From: Joe Vertel <J.Vertel@mosman.nsw.gov.au>
Sent: Friday, 25 March 2022 9:35 AM
To: Lara Fusco
Subject: RE: Request for advice - Taronga Zoo Nutrition Centre - SSD 17655146

I'm just seeking to confirm whether Mosman Council is likely to provide comments for the proposed Taronga Zoo Nutrition Centre (SSD 17655146)?

Drawing
ELEVATIONS - NUTRITION CENTRE

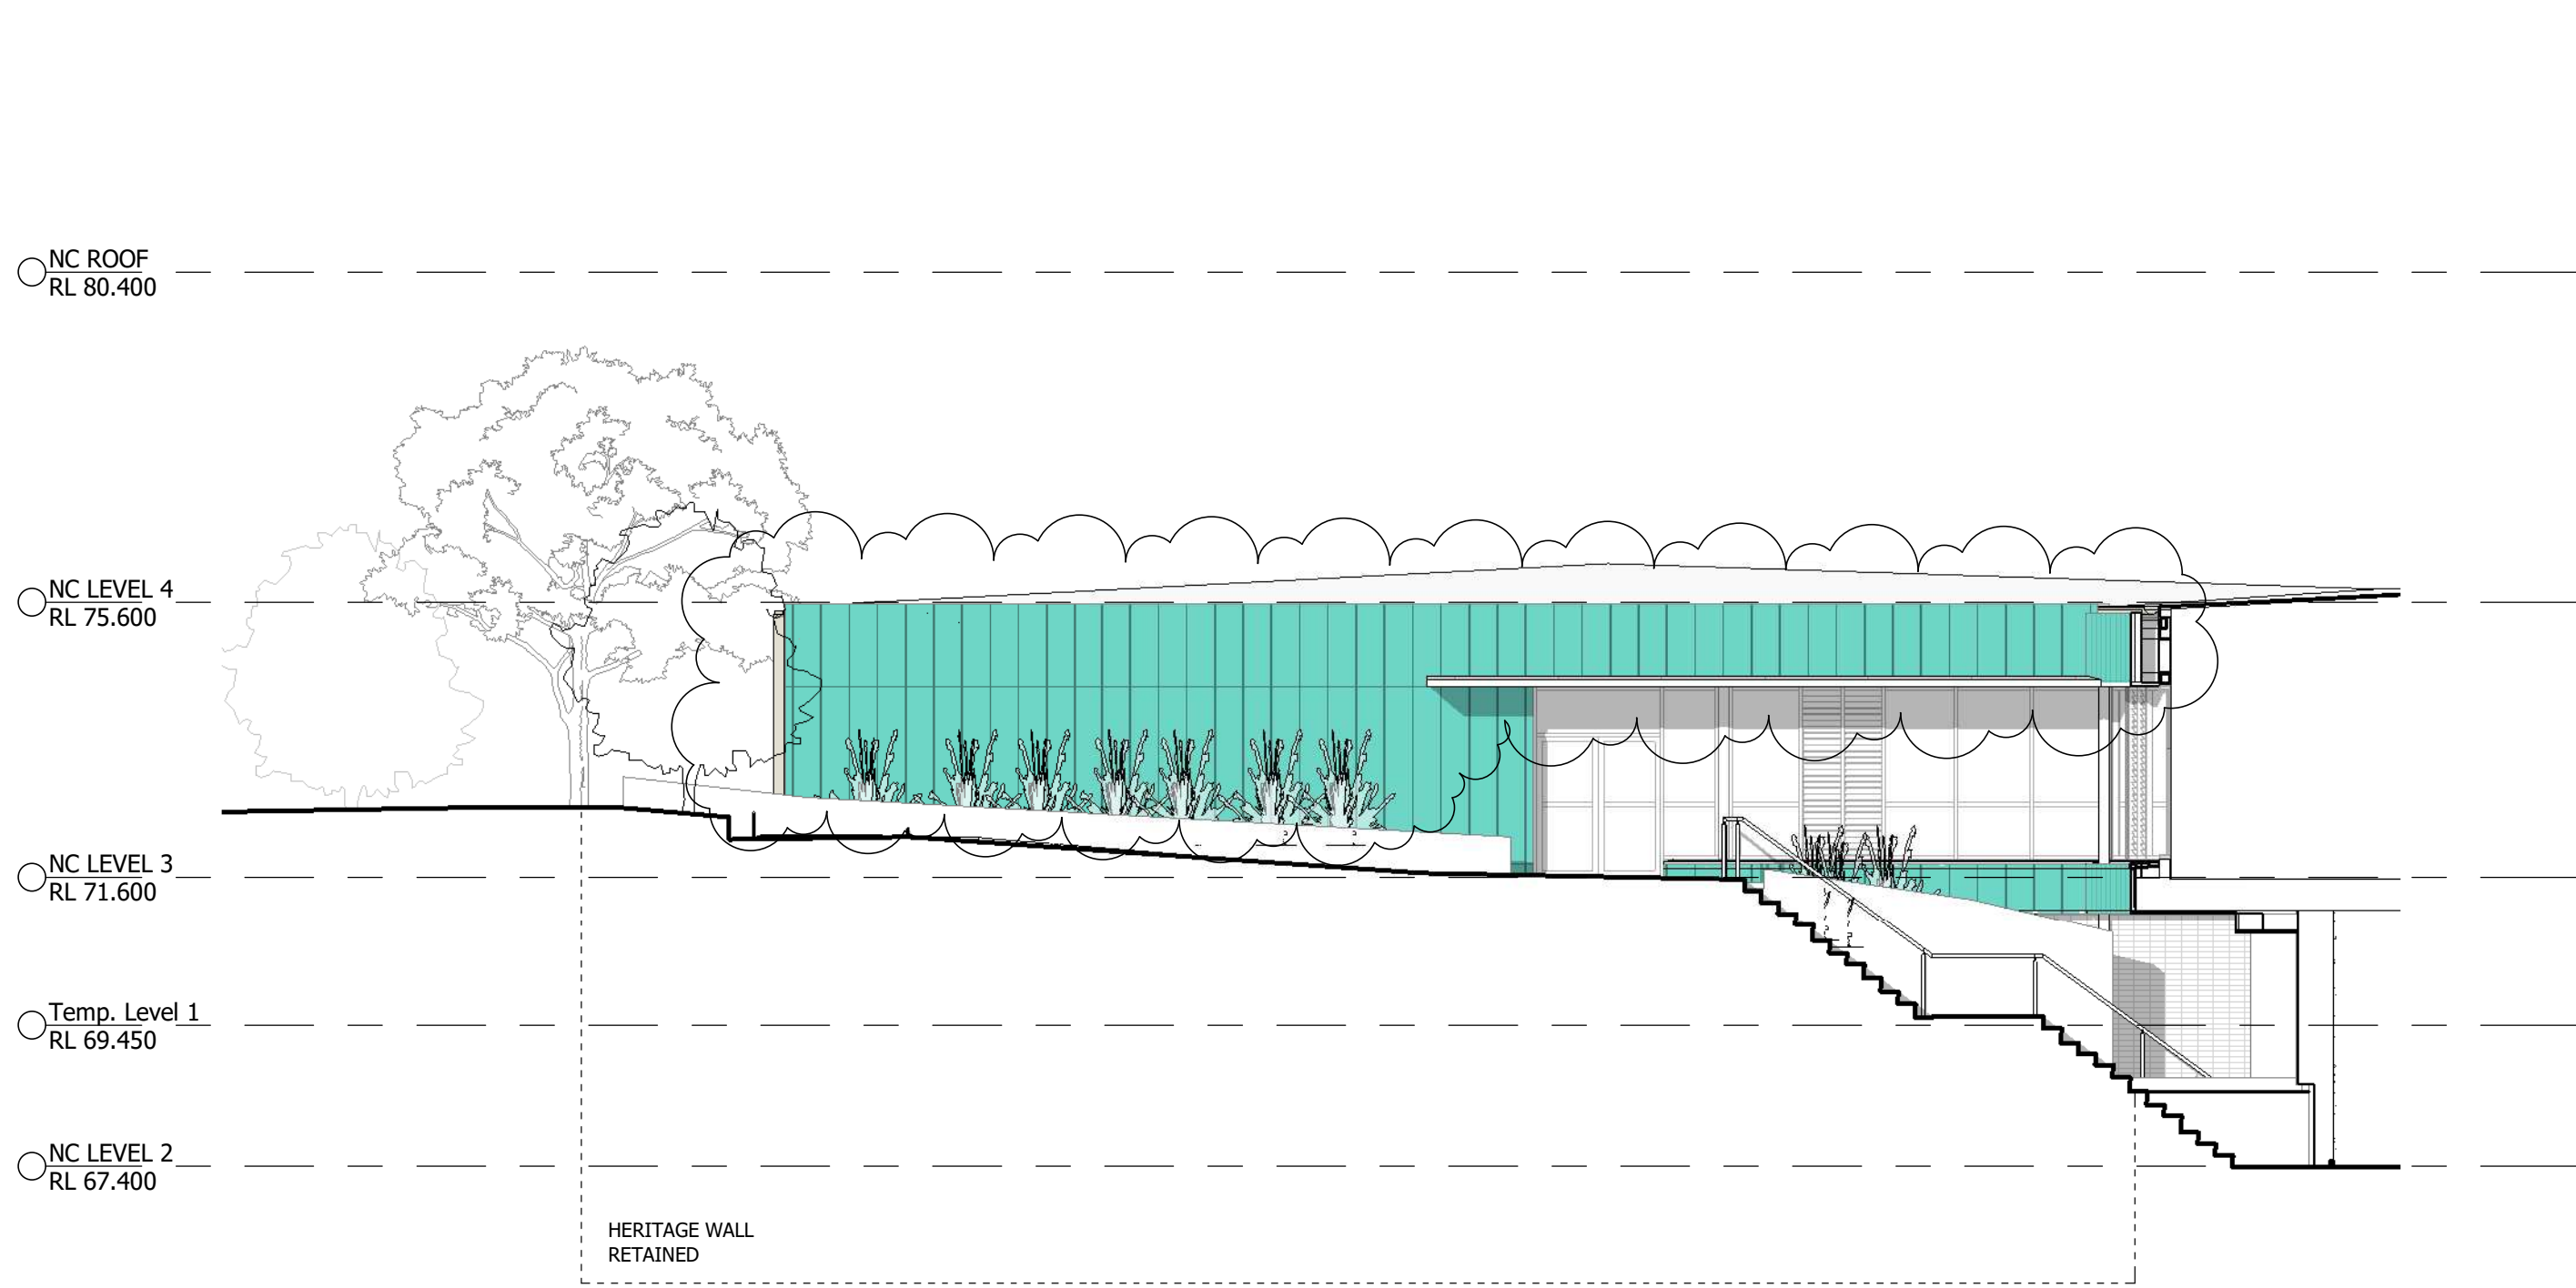
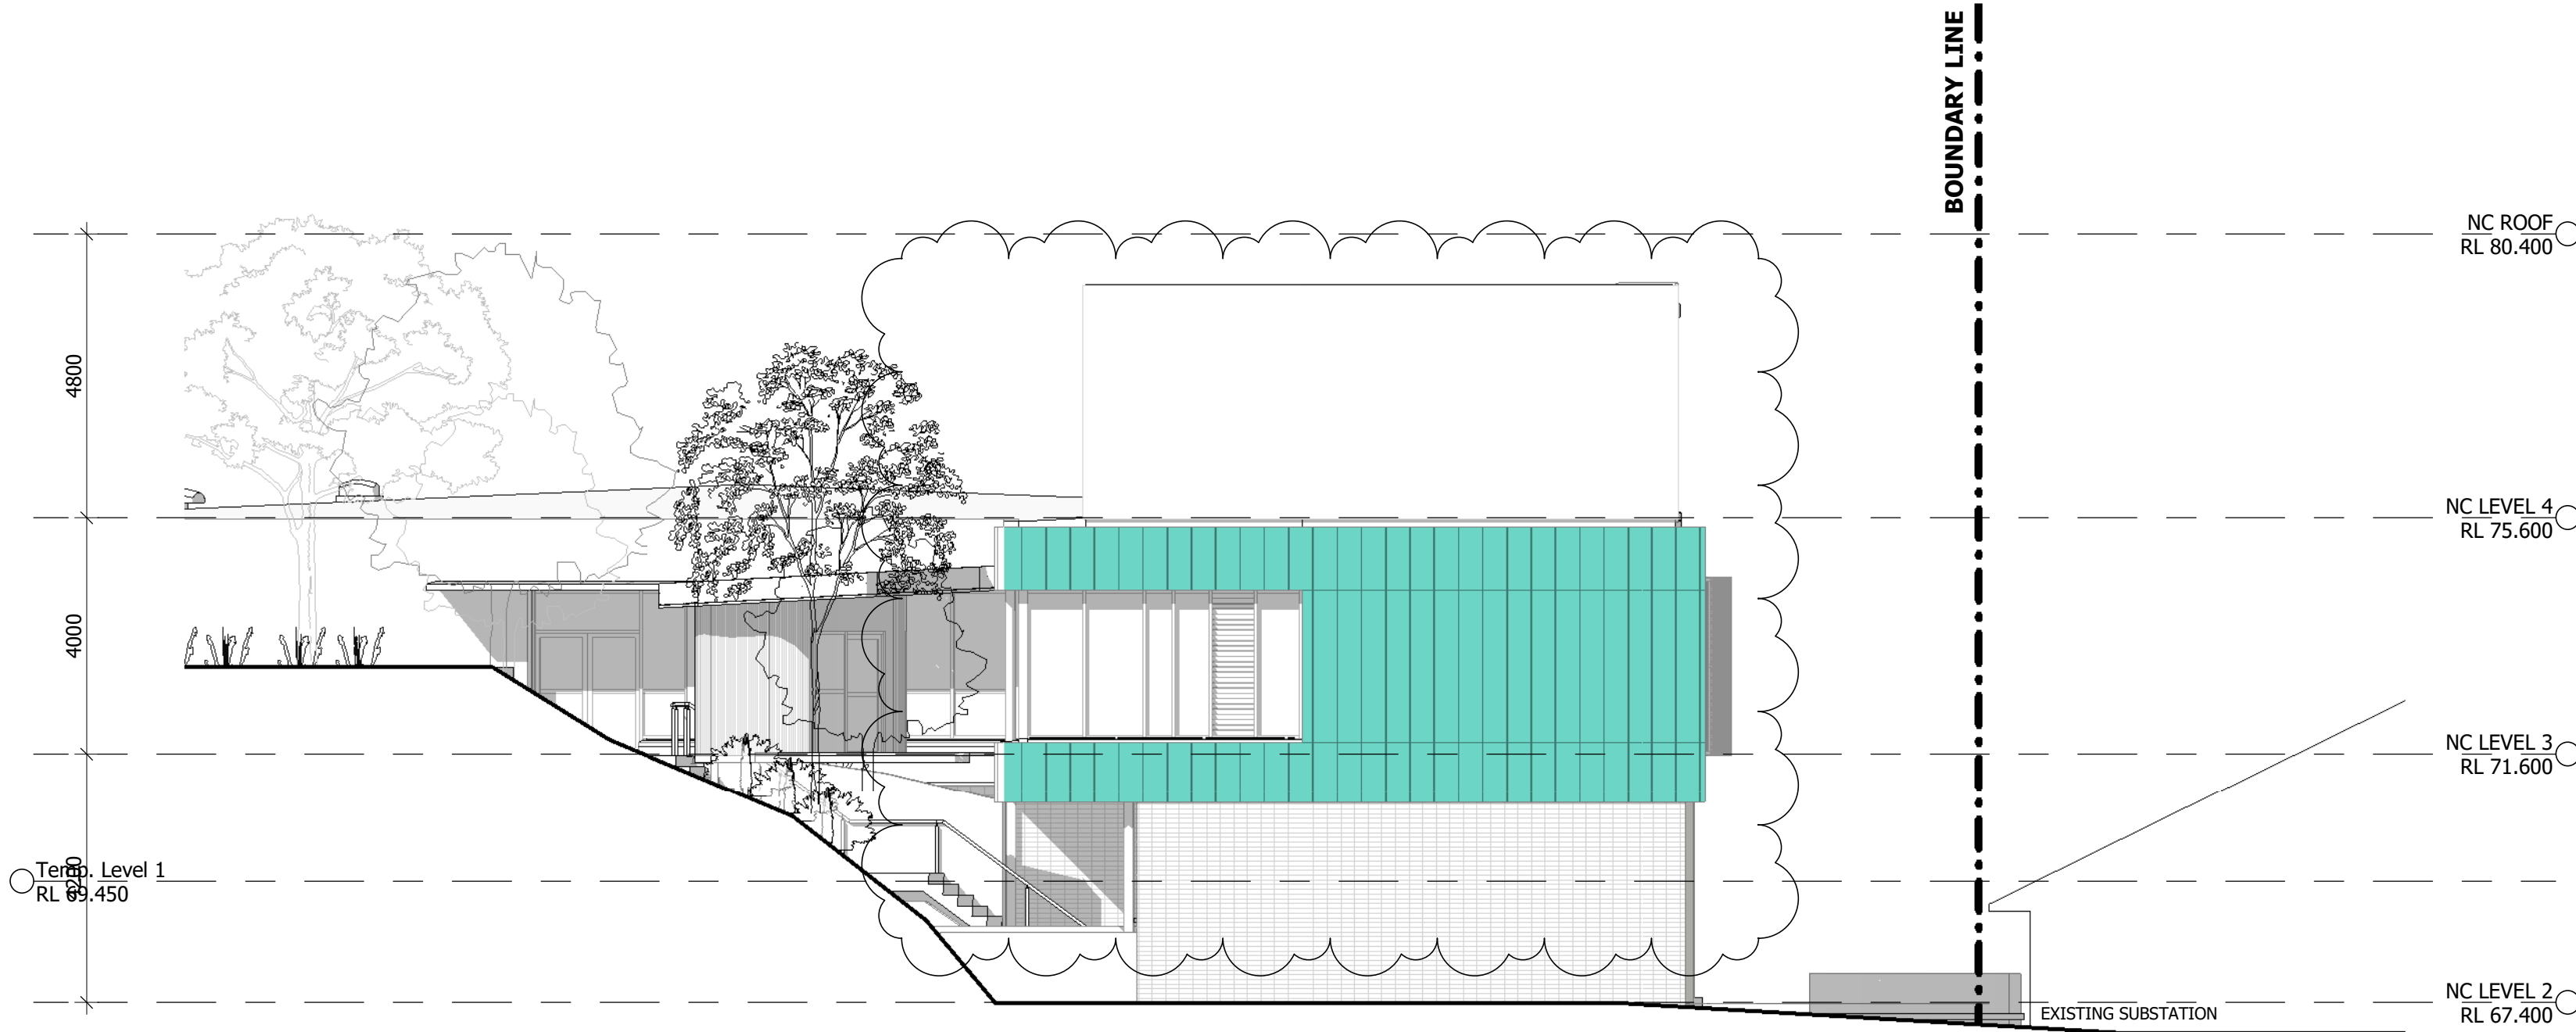
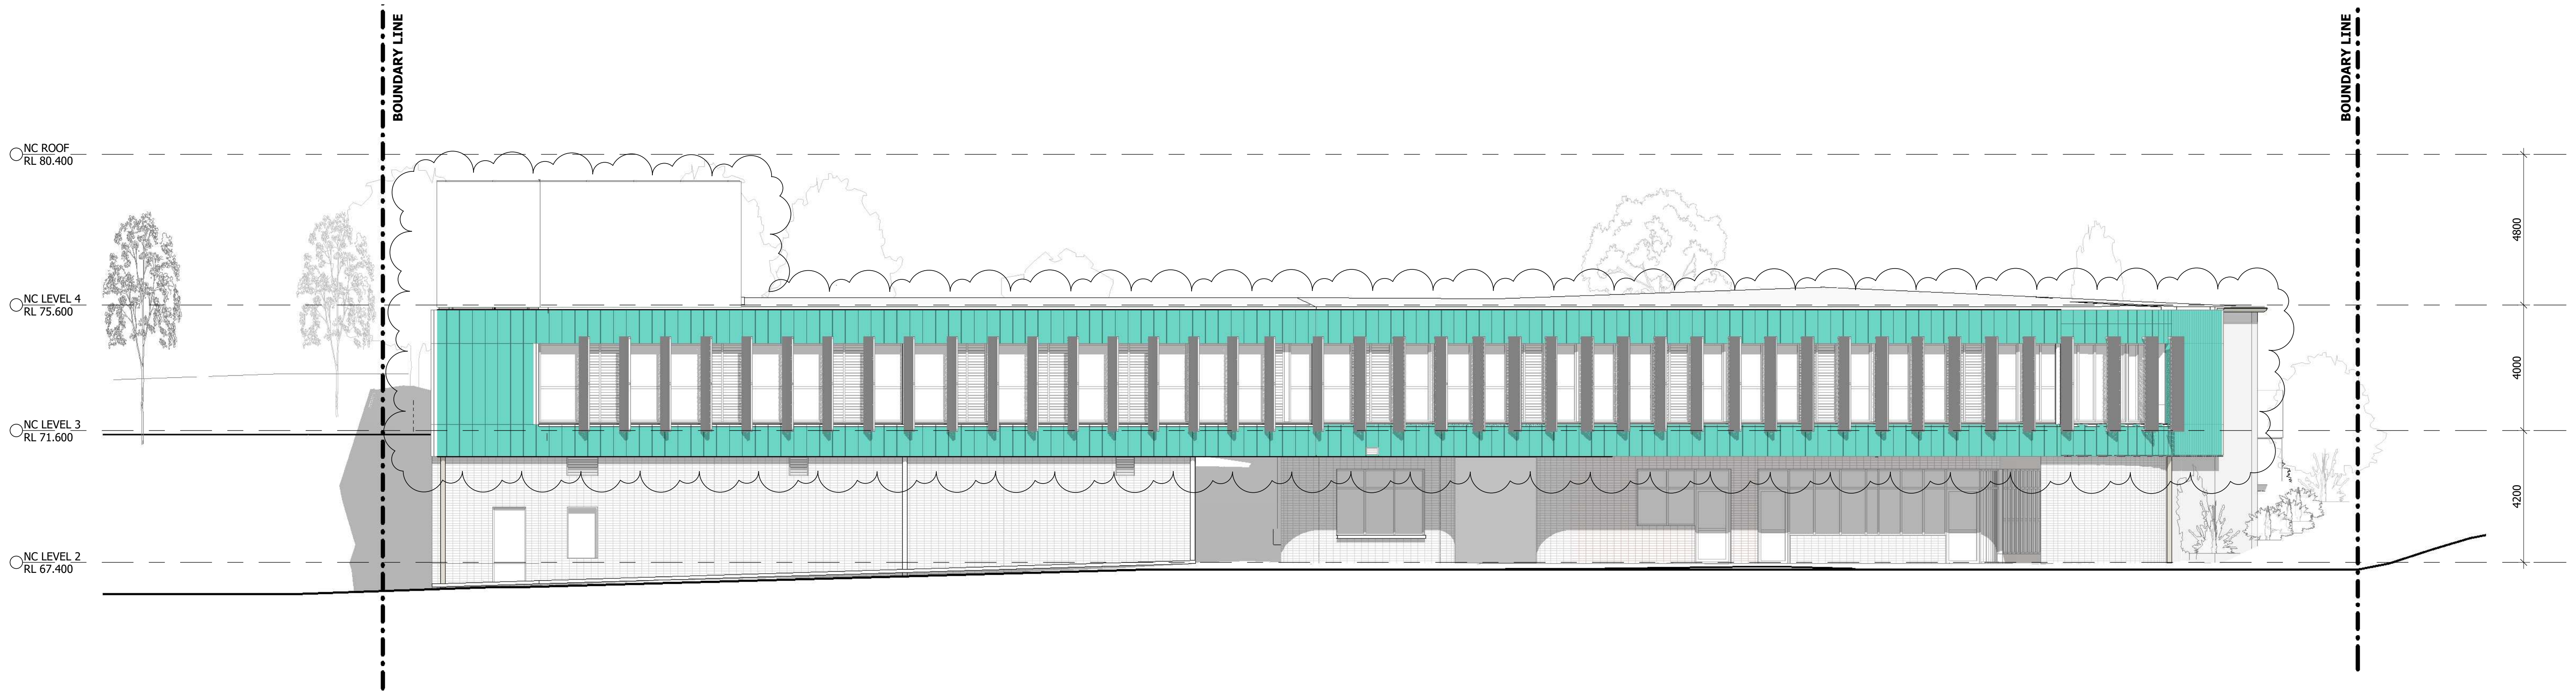
Based on the photomontages submitted (page 37 of the EIS), it appears that part of the building will be visible from the foreshores. It is recommended that conditions be imposed to ensure that suitable replacement tree canopy cover is provided to screen the building to ensure that landscaping dominates when viewed from the foreshores and that the materials/finishes of the building are sympathetic to the natural environment.
